Arun District Council
Arun Civic Centre
Maltravers Road
Littlehampton
West Sussex BN17 5LF
Planning General Enquiries
Tel: (01903) 737756 Fax: (01903) 730442
Dx: 57406 Littlehampton
Minicom: 01903 732765
e-mail: planning@arun.gov.uk
website: www.arun.gov.uk/planning

Our Ref: EG/43/15/HH

**Town & Country Planning Act 1990 (as amended)
Town & country Planning (Development Management Procedure) (England) Order 2015
Application for Householder Planning Permission**

Development Two storey extension, single storey extension & new porch.
Location Langham Legh Barnham Road Eastergate

LOCATION PLAN  
 Scale 1:1250 OS UK 100046326

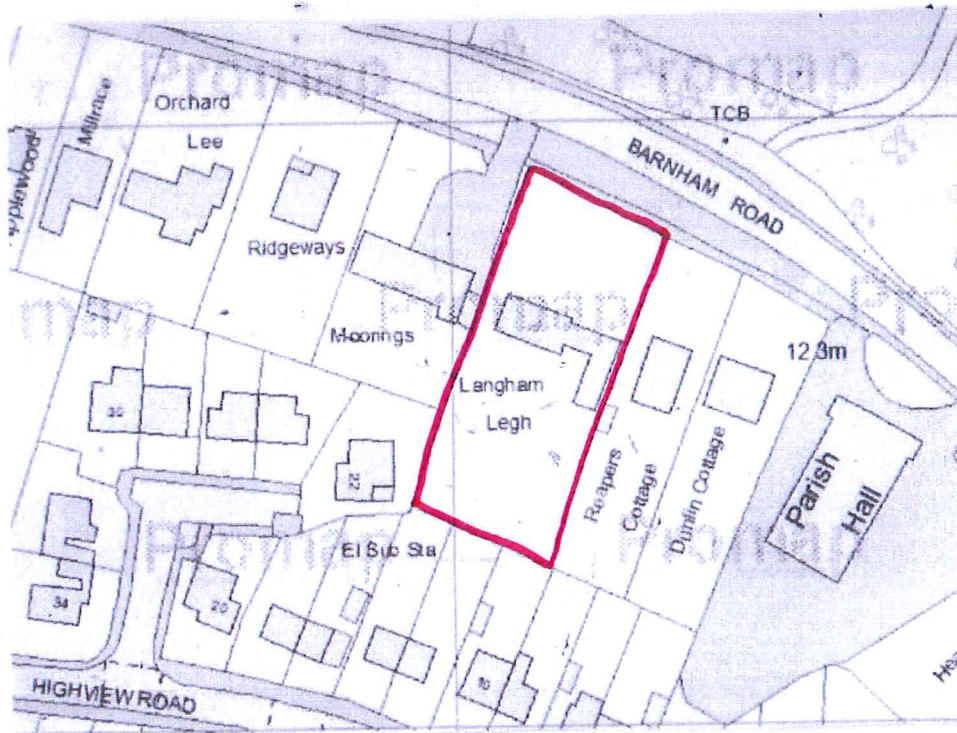
Please submit 1 electronic or 3 paper copies of an amended location plan to scale 1:1250 to include a red edge of the site boundary and a North point

BRICK PLAN scale 1:500 @ A4

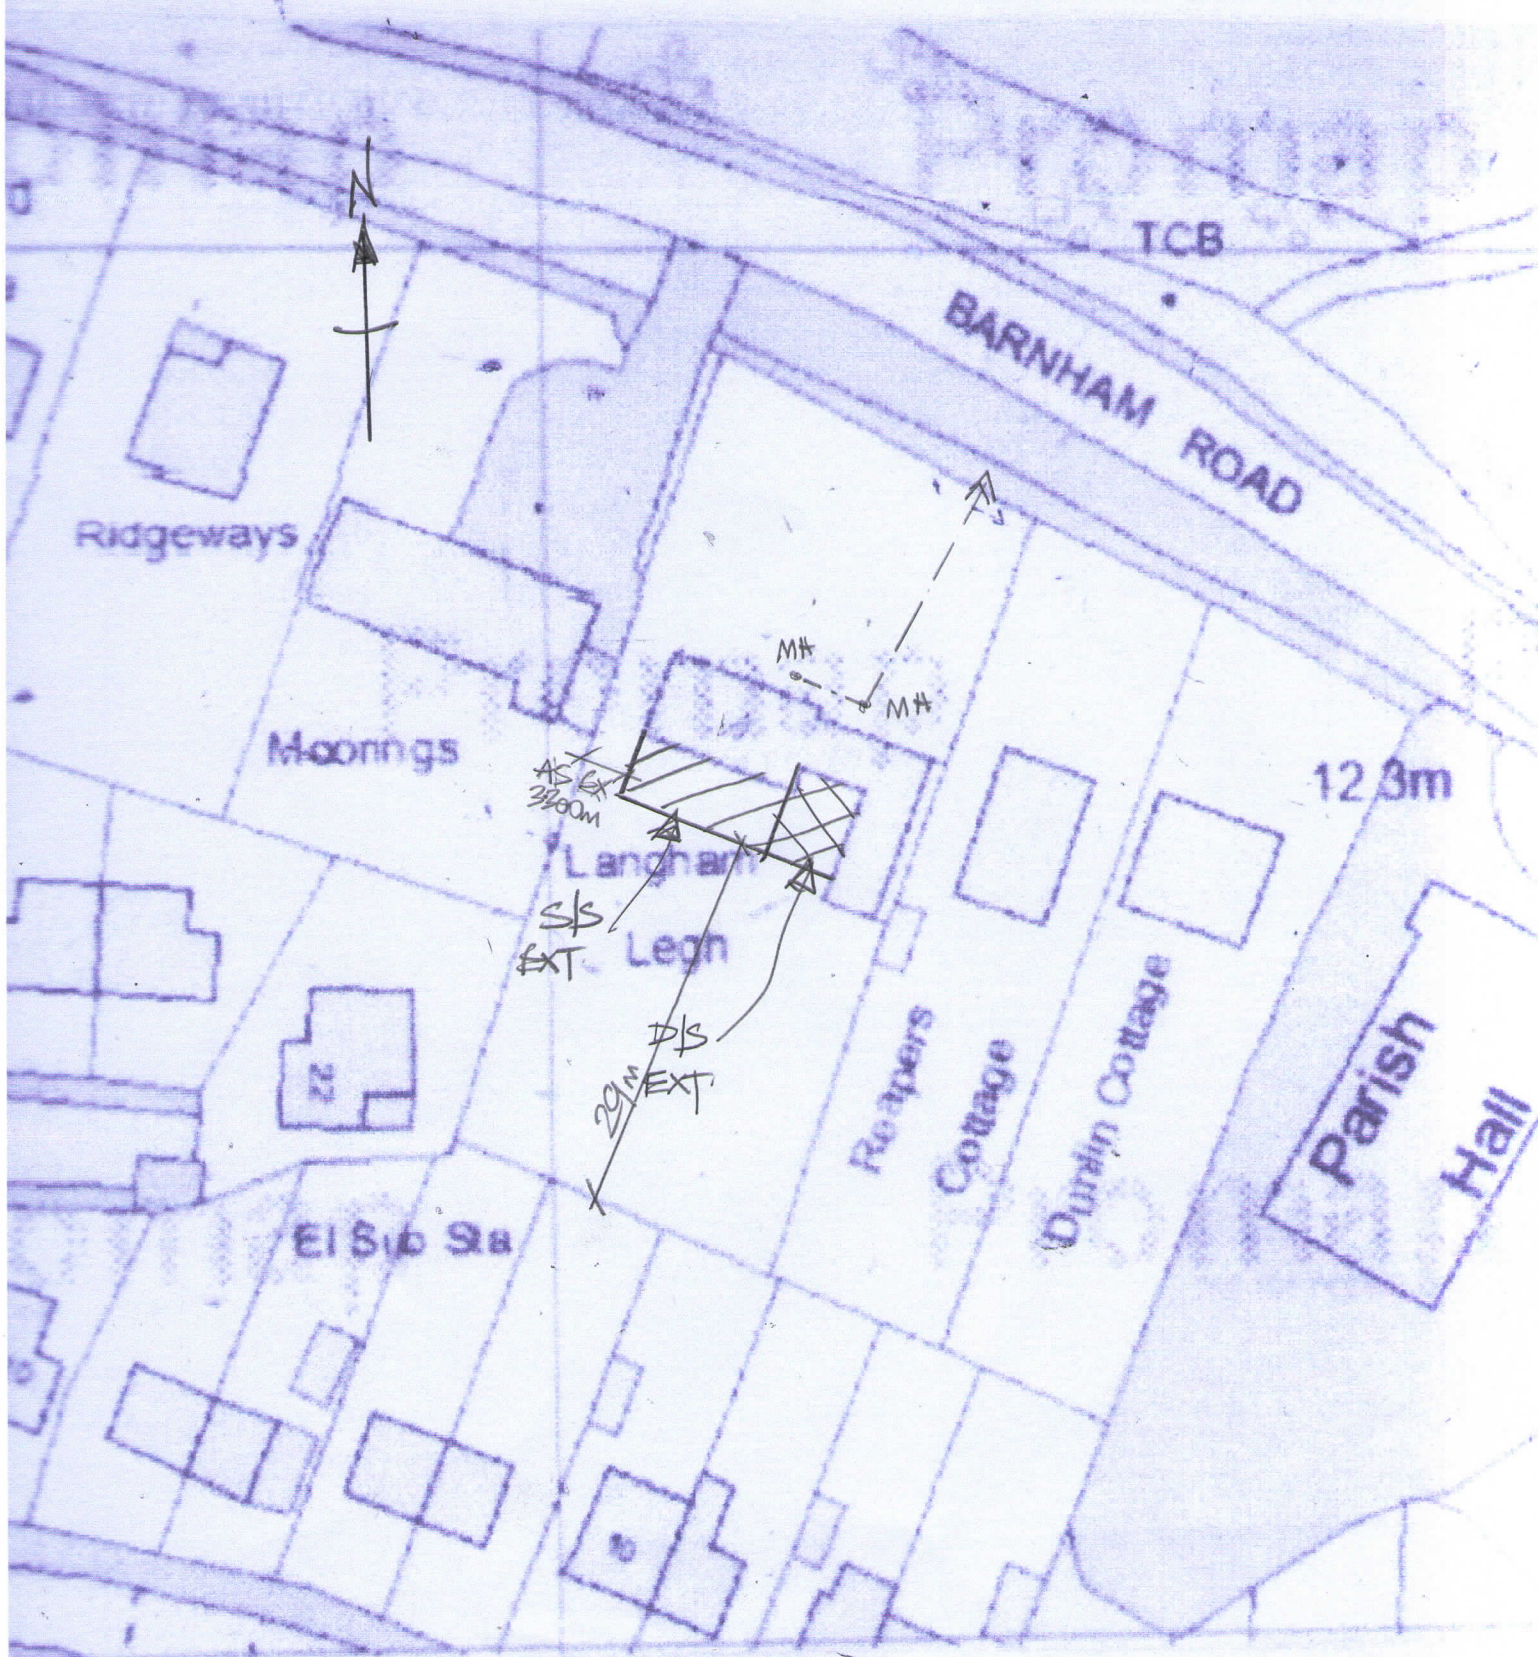
Please submit 1 electronic or 3 paper copies of a block/site plan at a scale of 1:500 or 1:200 with the proposals clearly shown to include dimensions to the boundary on the plan. Further details of what must be included on the plan can be found in the National Validation Requirements.
